Application No: EP/109/25/HH
Site Address: 94 North Lane East Preston BN16 1HE
Description of works: Proposed loft conversion, first floor rear extension and alterations to fenestration.

This council's Planning & Licensing Committee considered this application at its meeting on Monday, 15th December.

Drawing Name
Ground Floor, First Floor and Roof Plans -
Proposed

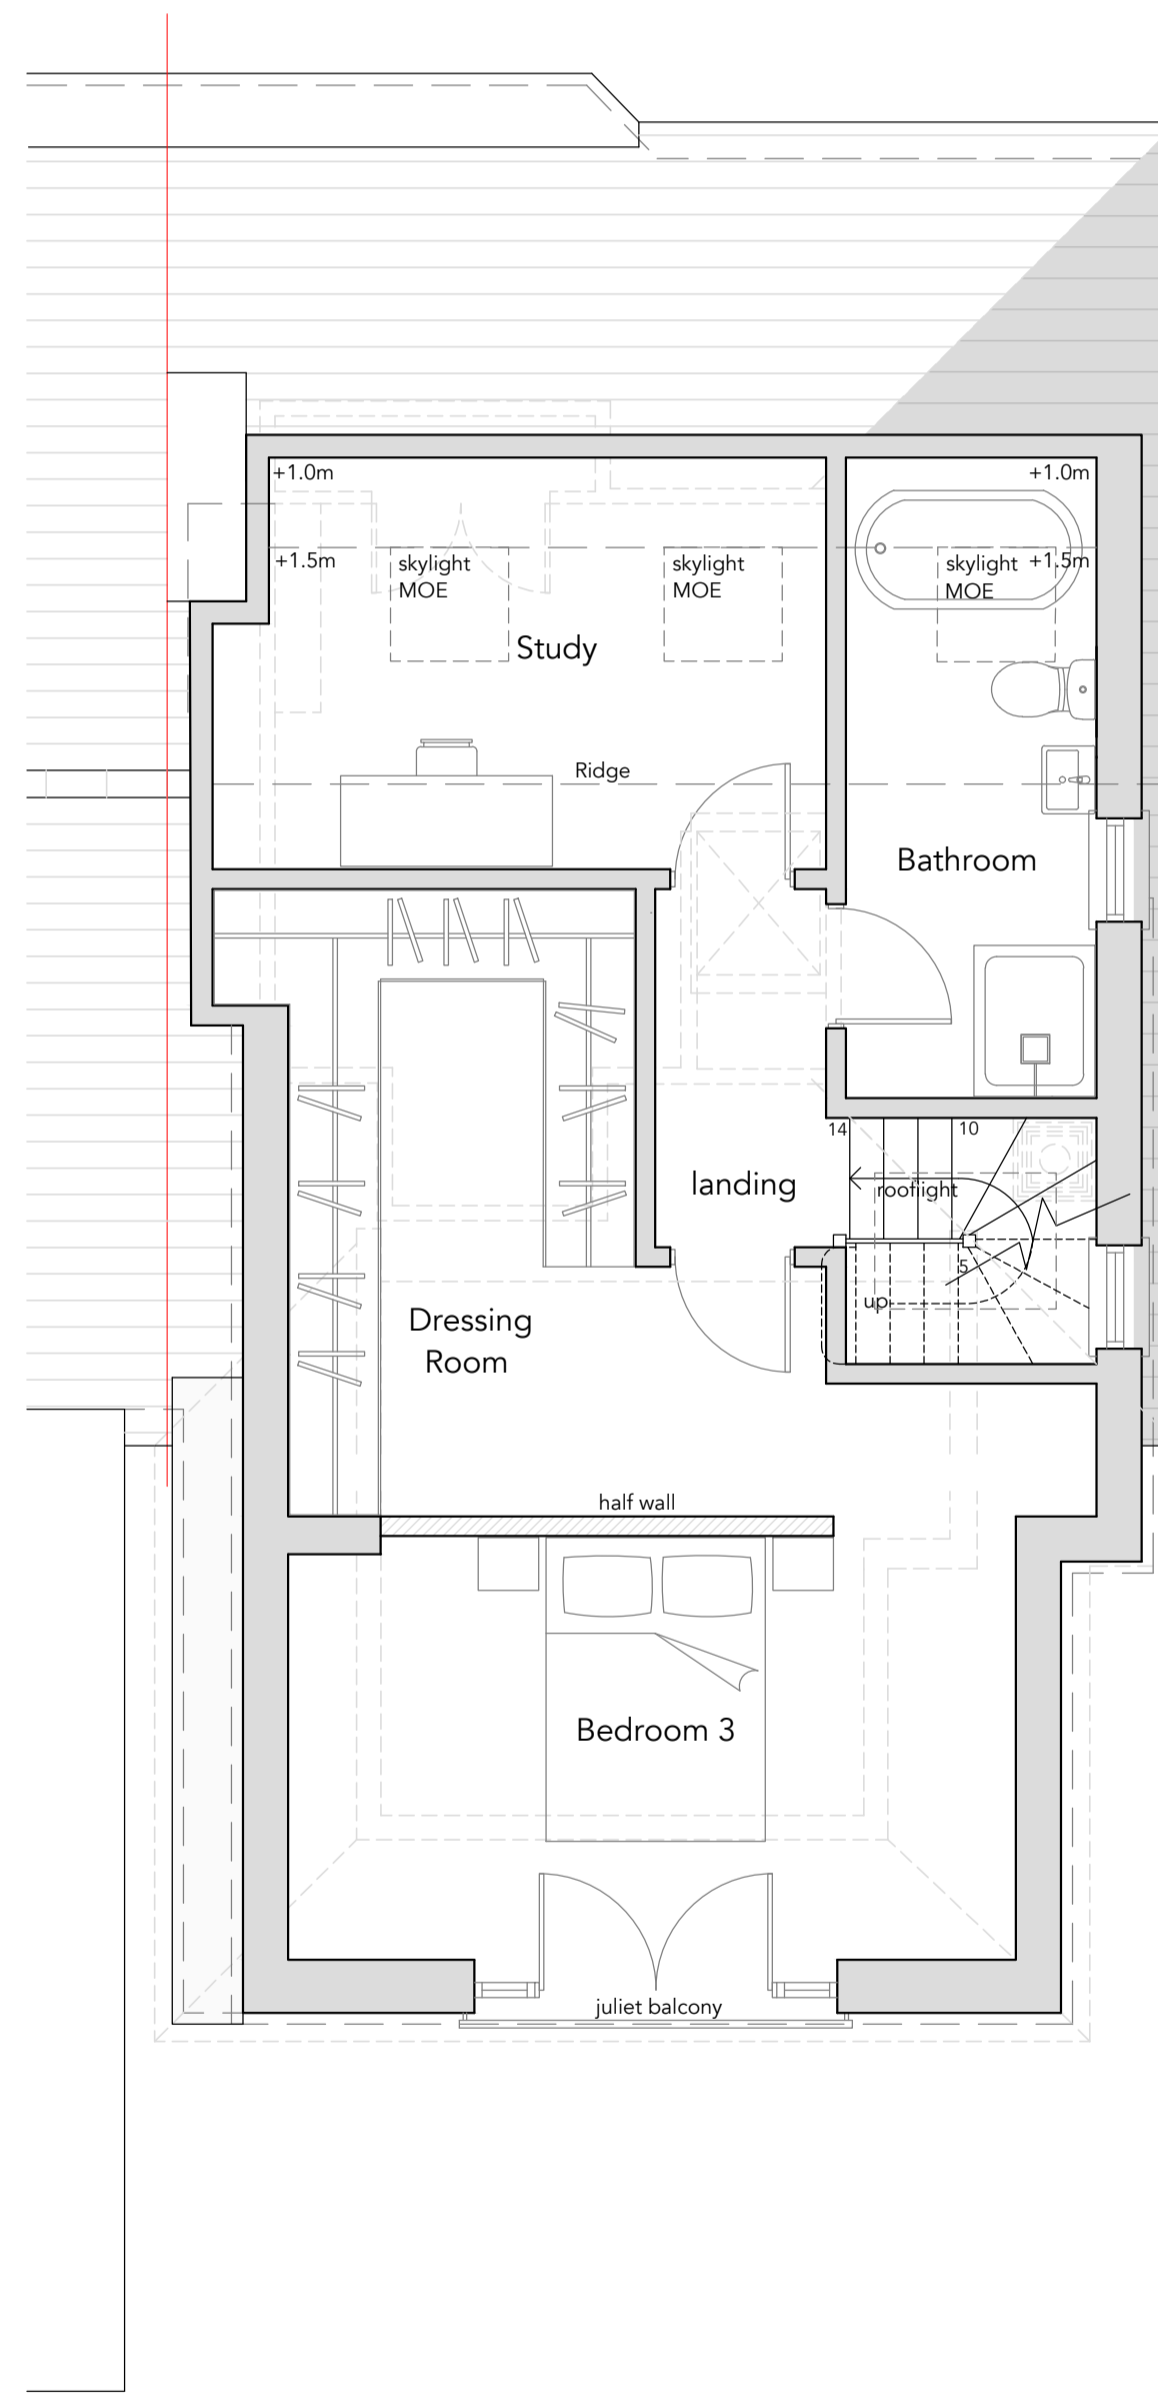
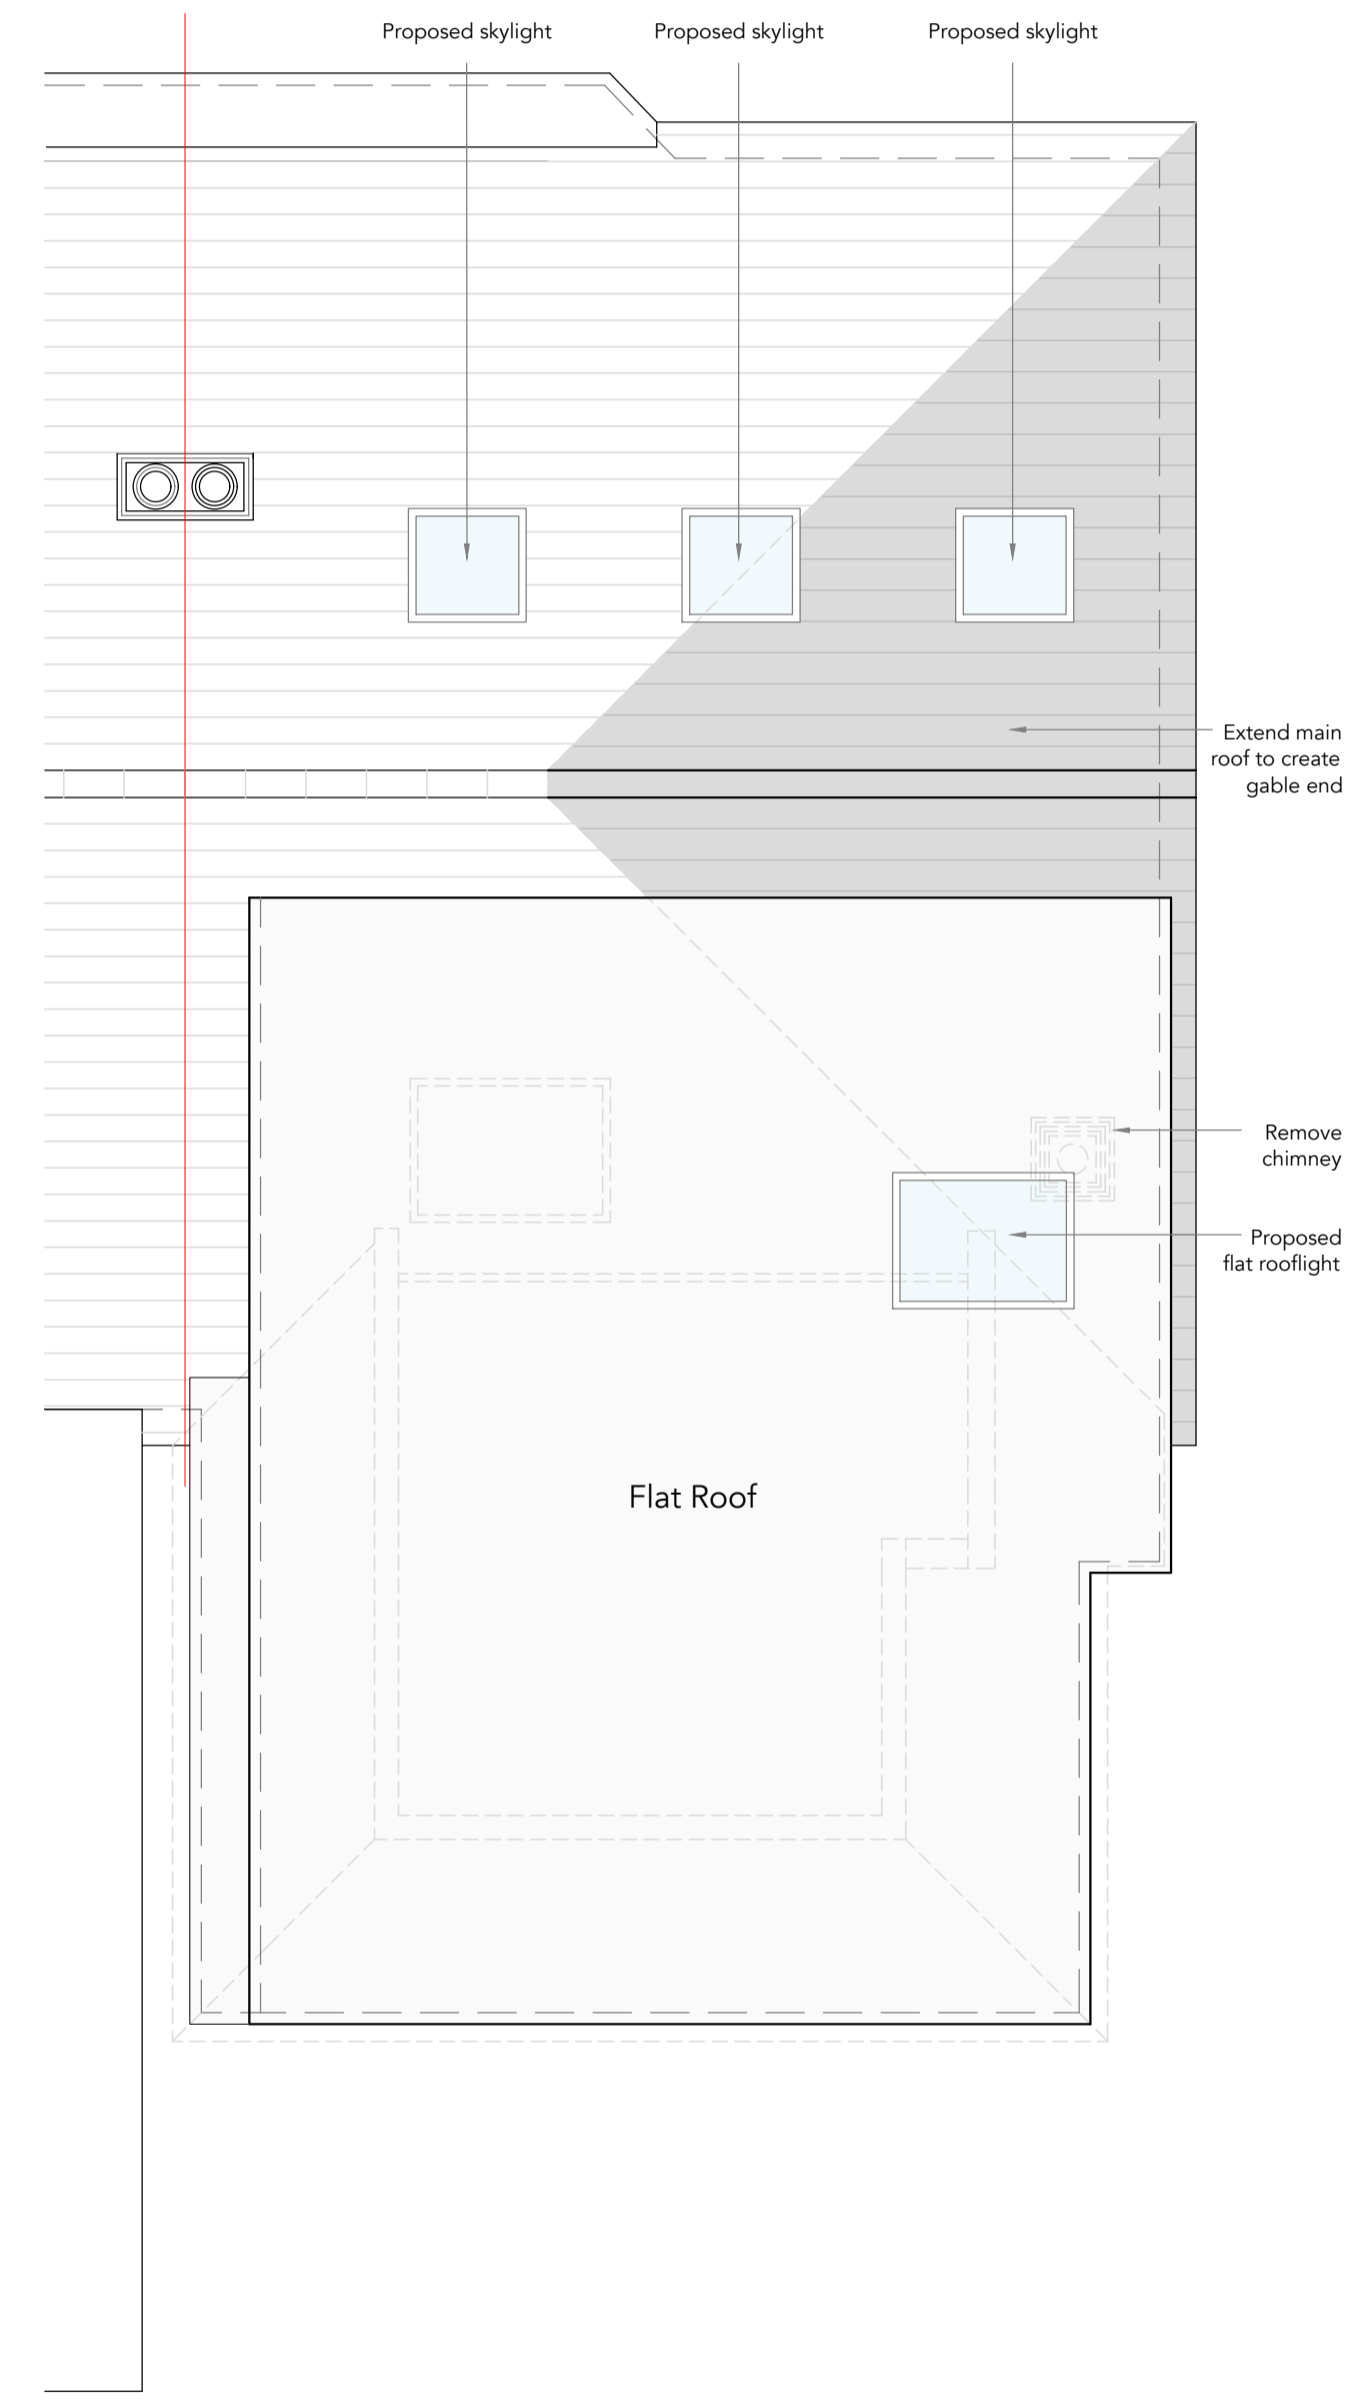
The committee asked ADC to be particularly aware of how the proposed alterations could unbalance this pair of bungalows. The committee was also concerned about whether the proposed two-storey extension at the rear of the property would lead to undue overlooking of the neighbours. The same concern was raised about the proposed Juliet balcony on the same elevation.
